## Inspector's Report ABP-313461-22

<b>Question</b>	Whether two extensions of 36.88sqm to a house is or is not development and is or is not exempted development.
<b>Location</b>	Ballynalahessery North, Dungarvan, Co. Waterford.
<b>Declaration</b>	
Planning Authority	Waterford City and County Council
Planning Authority Reg. Ref.	D5/2022/4
Applicant for Declaration	Thomas Gibson
Planning Authority Decision	No Declaration made
<b>Referral</b>	
<b>Referred by</b>	Thomas Gibson
<b>Owner/ Occupier</b>	Thomas Gibson
<b>Observer(s)</b>	None
<b>Date of Site Inspection</b>	8 <sup>th</sup> of June 2023
<b>Inspector</b>	Angela Brereton

- 2.1. I consider that the question to be determined by the Board is as follows:
- 2.2. Whether the construction of two extensions of 36.88sq.m to a house is or is not development and is or is not exempted development at Ballynalahessery North, Dungarvan.

Plan of House showing Proposed Extensions

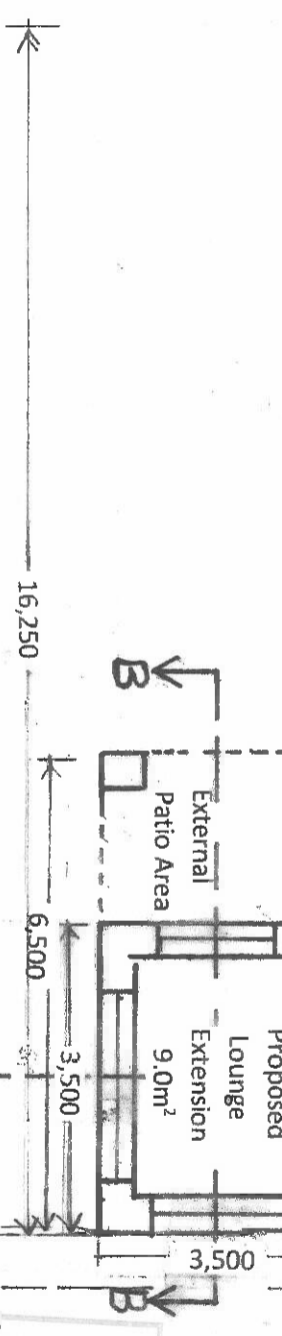
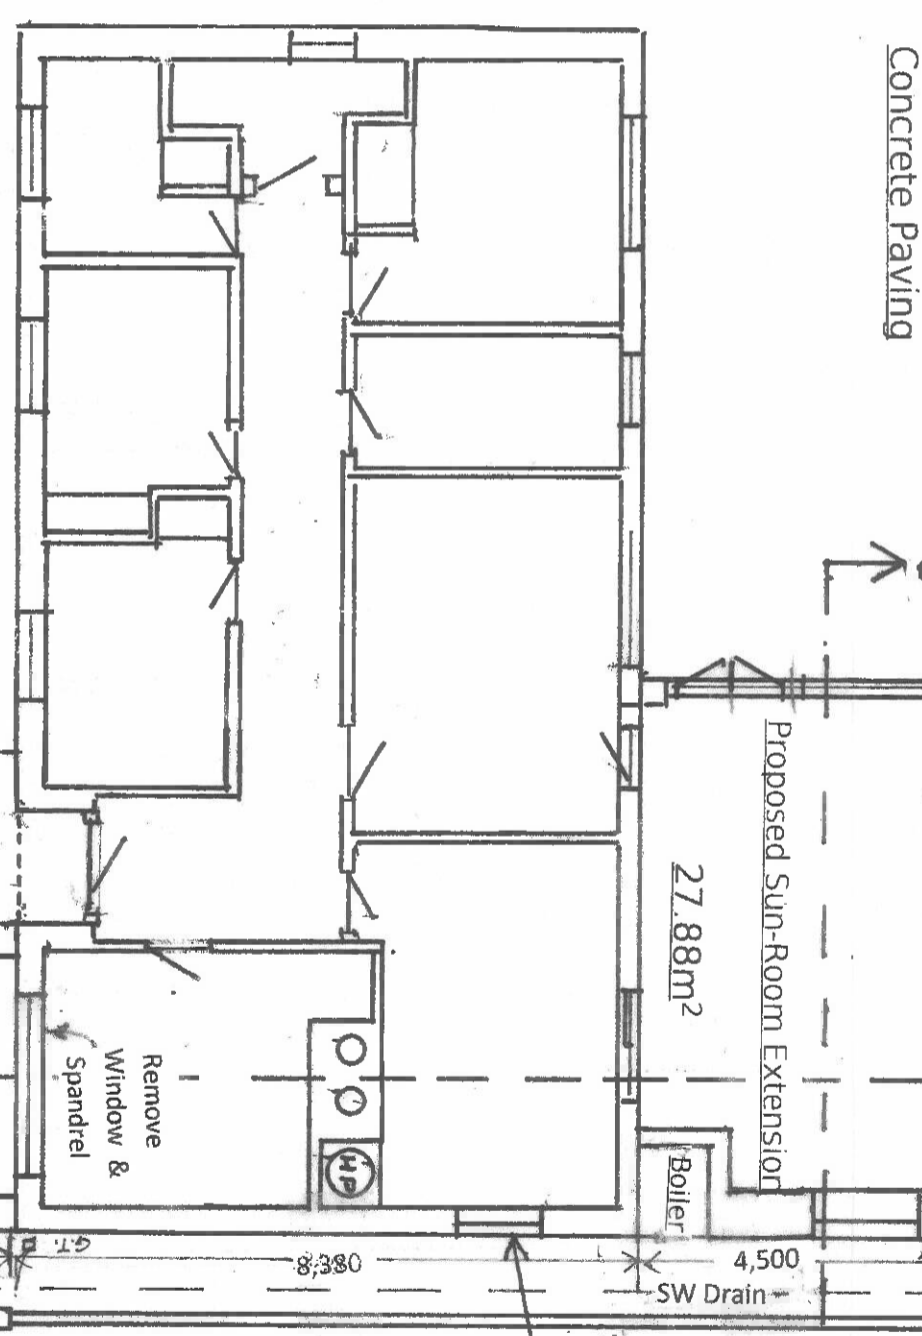
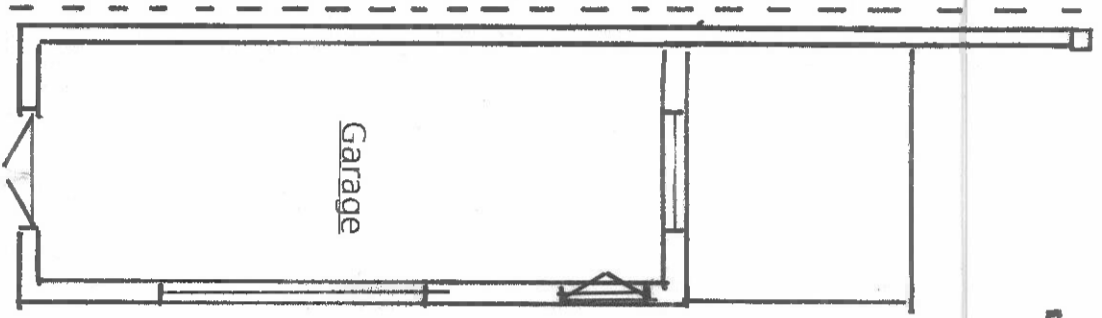
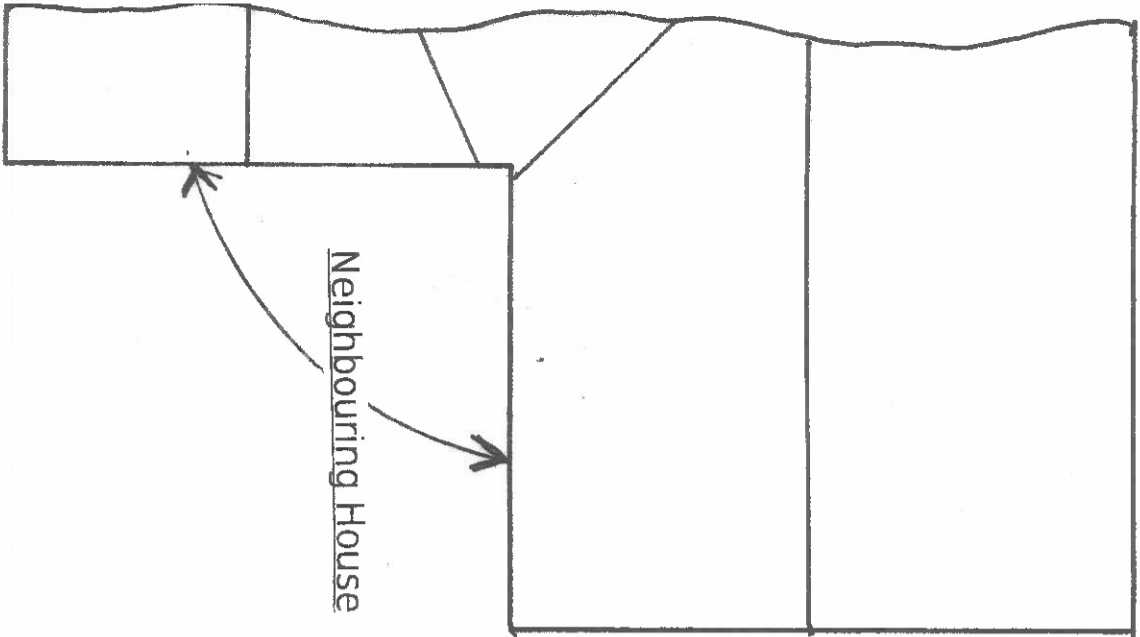
- 9.4.1. In terms of Class 1 of Part 1 of the Second Schedule to the Regulations, there are a number of conditions and limitations that must be met in order to consider the extensions as exempted development. In terms of these conditions and limitations, having regard to the details including the drawings submitted, I am satisfied that the two key issues arising with regard to floor area and height (less than 4m) are met as it has been noted that the combined floor area of the front (9sq.m) and rear (27.88sq.m) are less than the 40sq.m provided by the exemption.

- 9.4.3. Therefore, in this case, it is clear that the proposed rear extension at 27.88sq.m and shown c.3.6m in height would constitute exempted development. However, the proposed front extension at 9sq.m would not constitute exempted development under this Class, as it would be to the front rather than to the rear or side of the development.

Front Elevation showing proposed Lounge Extension.

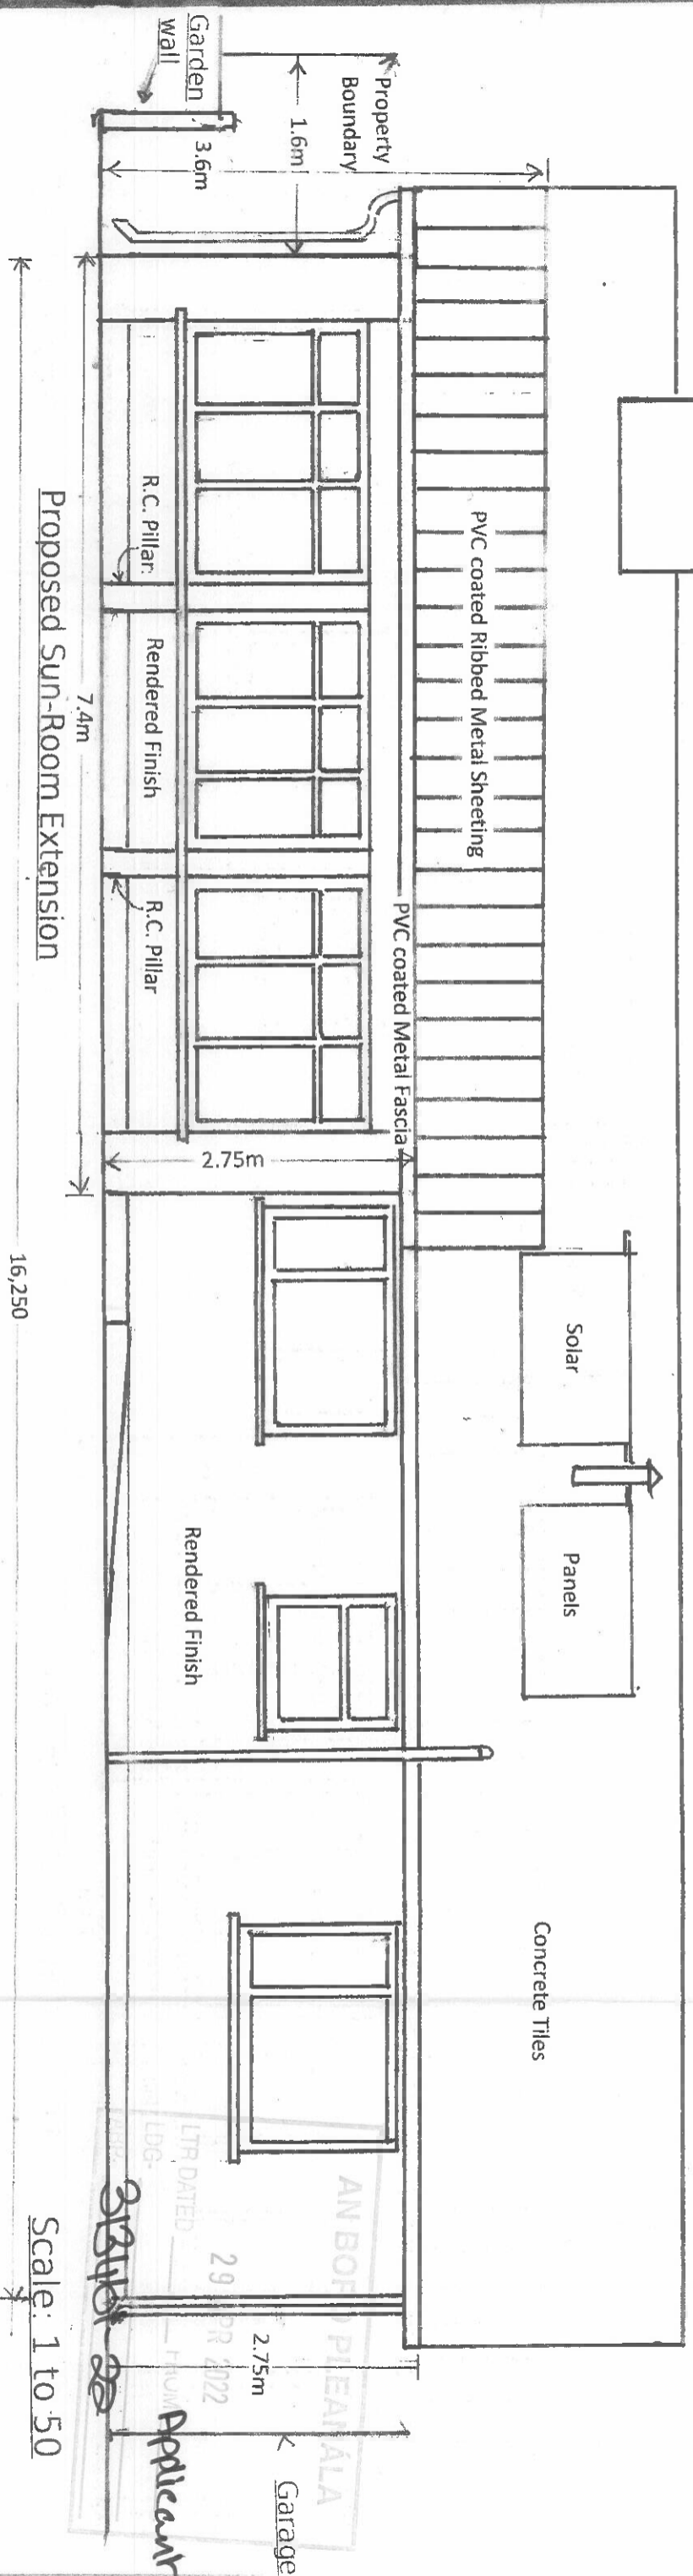
- 9.4.4. It would also not fall into Class 7 of Part 1 of the Second Schedule to the Regulations, which is relevant to porches. This is because it would exceed the stipulated area of 2sq.m.

- 9.6.1. However, while the Referrer's comments are noted, I would not consider that the proposed front extension would fall within the scope of the exemption as per Section 4(1)(h) of the Act. It relates to the carrying out of works for the maintenance, improvement or other alteration of any structure. There is no provision made in this Section for an exemption for extensions.
- 9.6.2. Nor, as has been discussed, would the proposed front extension fall within the exemptions offered by Class 1 or Class 7 of Part 1, Schedule 2 of the Regulations.

9.6.3. Therefore, in this case I would recommend that a split decision be made i.e. that the proposed rear extension would be exempt under the said Class 1, but that the front extension would constitute development that would not be exempted development.
